**From:** Amanda Scholes on behalf of Planning.Responses  
**Sent:** 25 February 2020 13:10  
**To:** Planning Scanning  
**Subject:** FW: 30, Devonshire Road, PO21 2SY (BR/283/19/OUT)

The application has been passed up the chain of management and assessed for suitability for sign off. As you will know, it is the responsibility of Officers to put an applicant's best foot forward with the intention of achieving a positive determination. However, following further scrutiny it has been found there are two principal issues with the development proposals. These are set out in full below for your understanding:

ILLUSTRATIVE DRAWING:  
form and massing - B

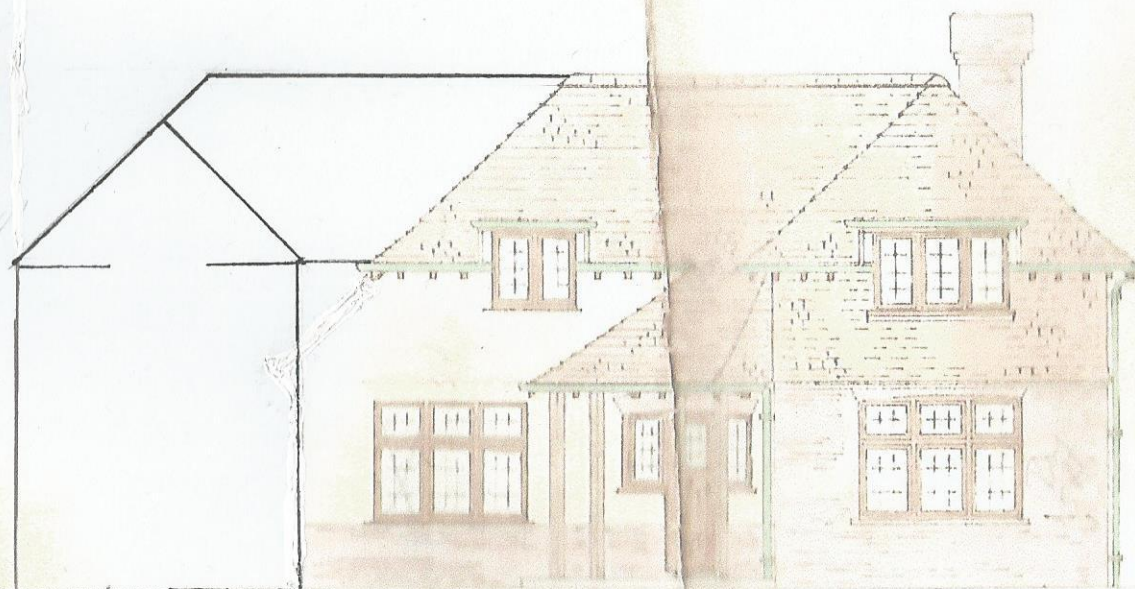
- 1. The form capable of achieving acceptable internal space standards would result in the erosion of the established urban grain which would result in a building with a discordant massing and uncharacteristic scale which would be at odds with the prevailing character of the area; contrary to Policies D SP1, D DM1 and D DM4 of the Arun Local Plan and paragraphs 127 and 130 of the National Planning Policy Framework (2019).*
- 2. The submitted red line would result in a loss of parking provision for the existing apartments on the site which would result in cumulative impacts upon parking provision for the existing occupants and would fail to provide safe and sufficient access for the transport demands created; contrary to Policy T SP1 of the Arun Local Plan and paragraph 108 and 109 of the National Planning Policy Framework (2019).*
